From: DataSpace Consult [system@dataspaceconsult.co.uk]
Sent: 28 July 2015 14:41
To: Planning
Subject: Comments Added: Plot 6000, Hatfield Business Park, Hatfield

Application ID: S6/2015/1061/MA - Mr M Peacock Application Owner: Welwyn & Hatfield Borough Council(Development Management Officer)

Location: Plot 6000, Hatfield Business Park, Hatfield Deadline Date: 10/07/2015 00:00:00

Description: Erection of a private healthcare facility (use Class C2), to include car/cycle parking, boundary treatment, landscaping, lighting and access Comment Added:

Drawing title:
 Phase 2 Proposed Site Plan
 and Landscaping Proposals

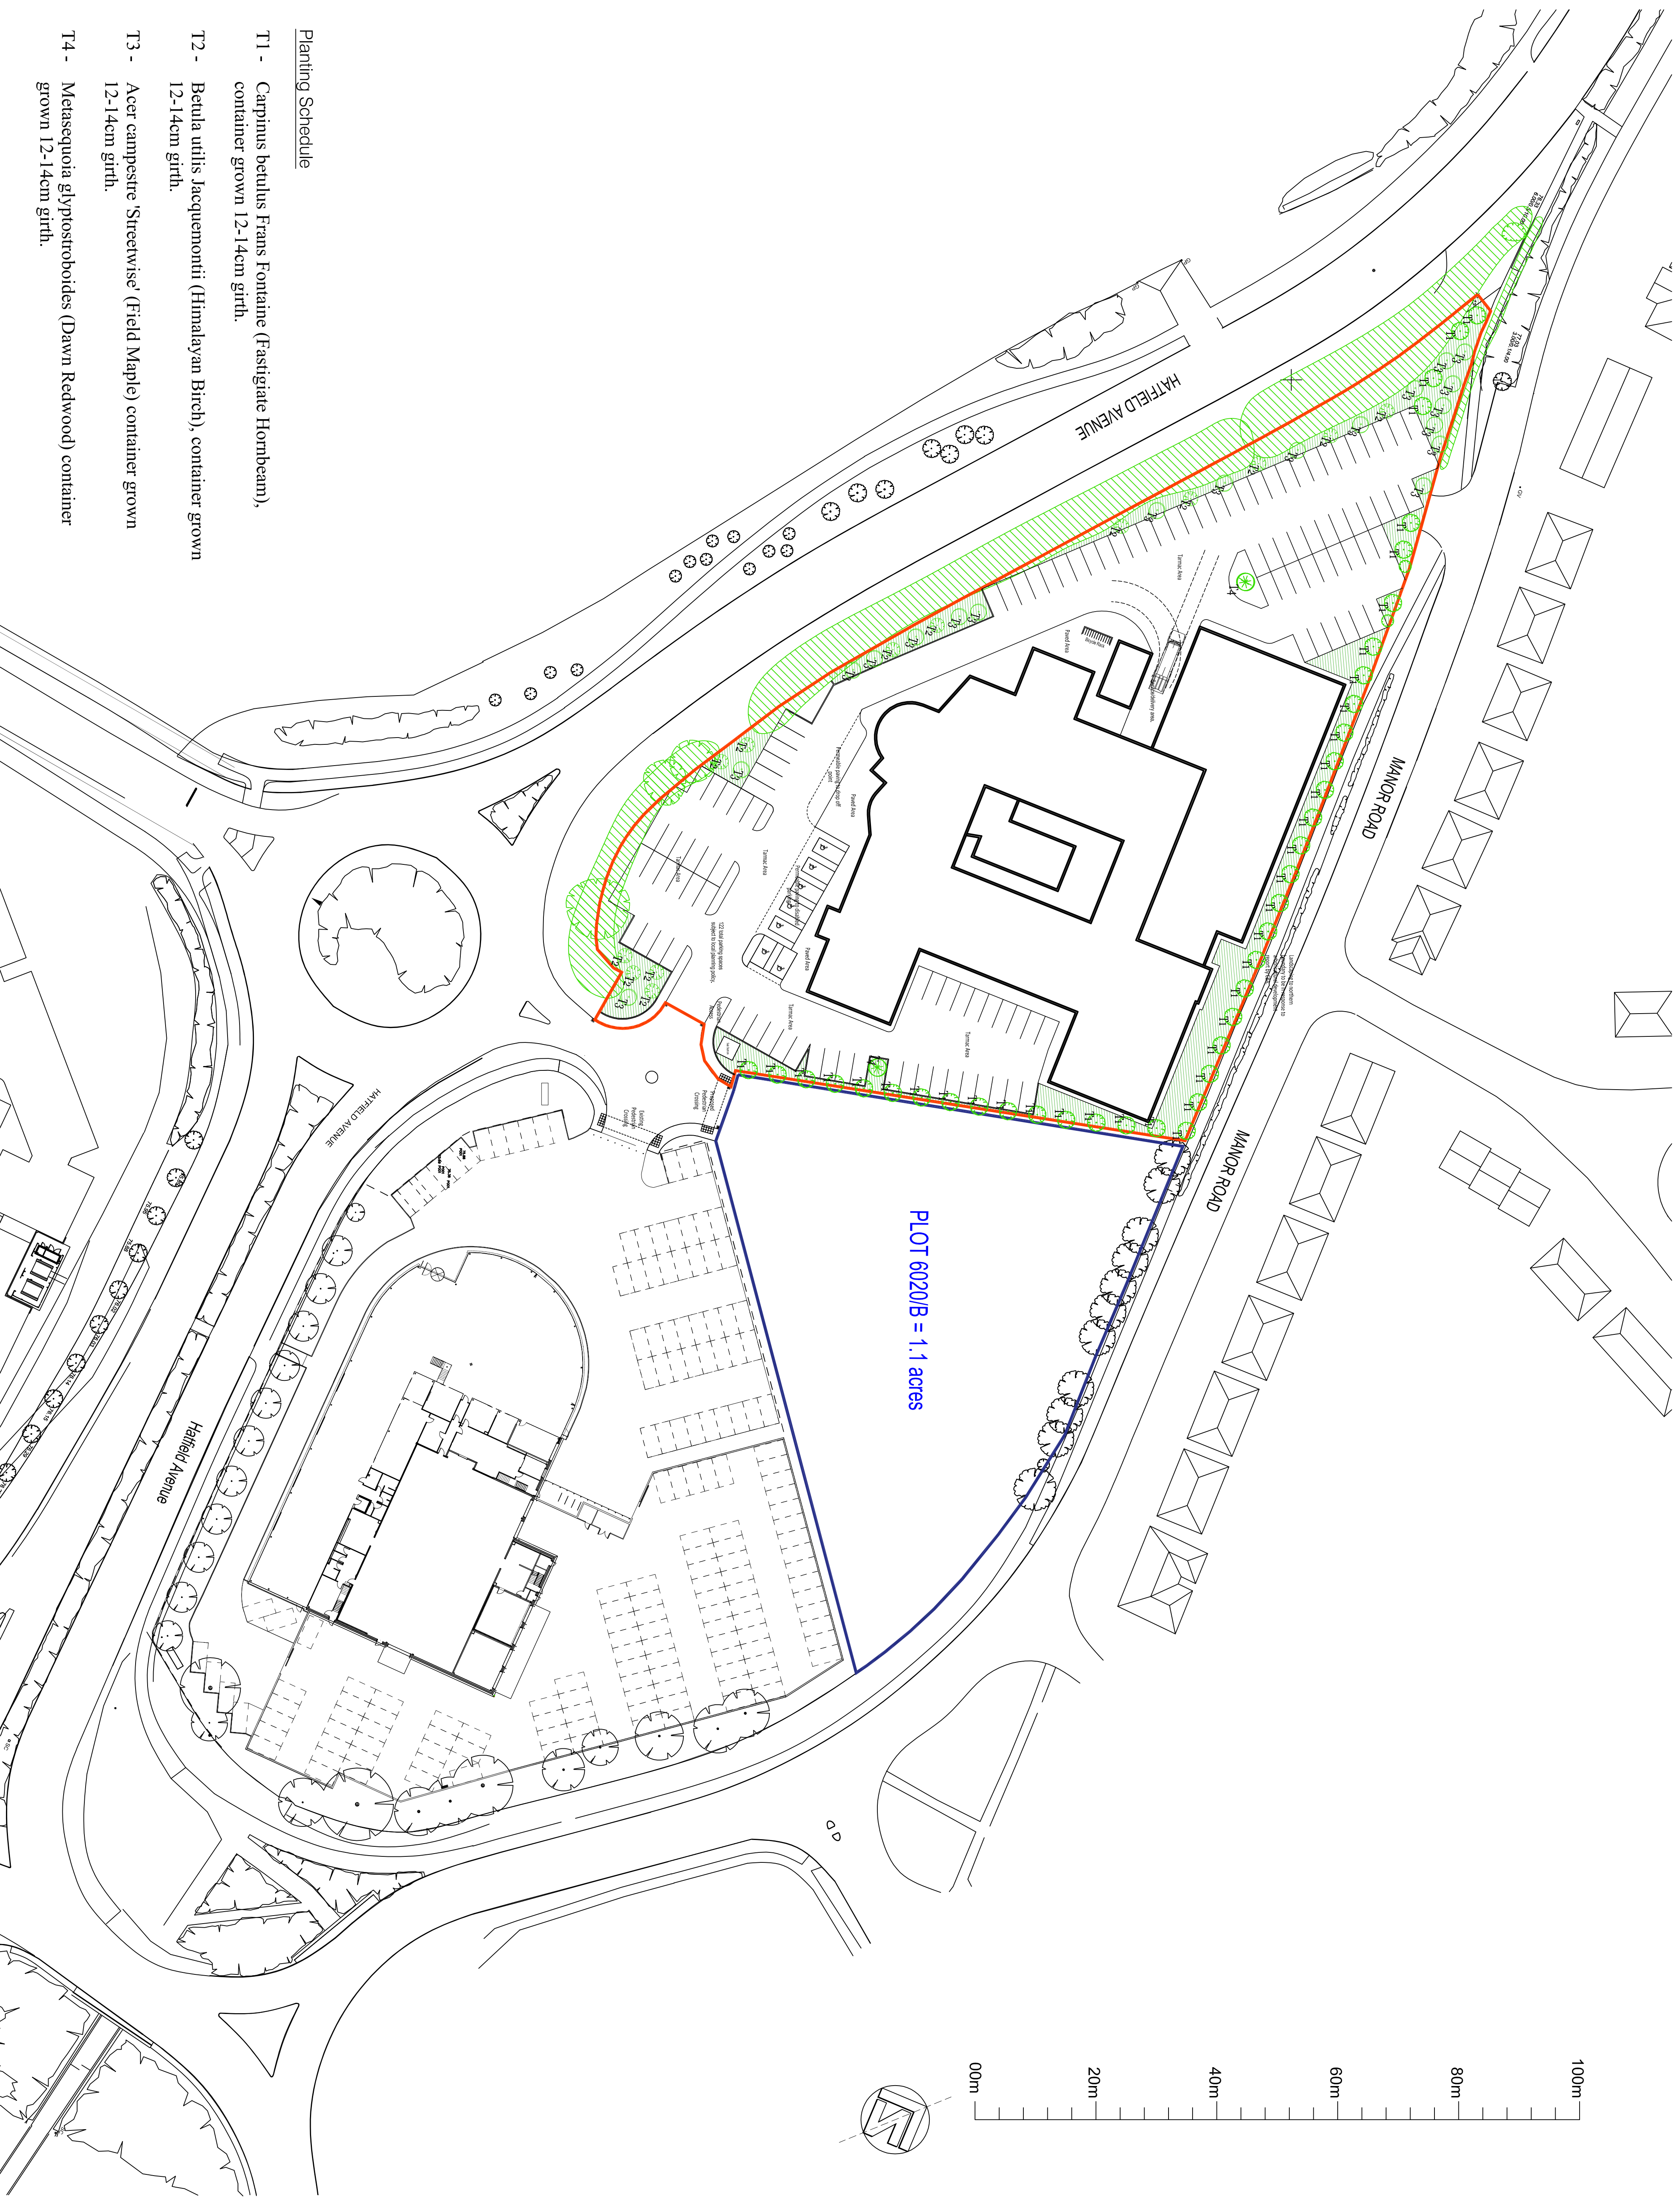
Concern is expressed on the car parking and the potential shortfall in provision for employees, patients, suppliers and patient visitors.

Concern is expressed on the pedestrian access into manor road and potential for employees and visitors to park off site and cause parking issues.
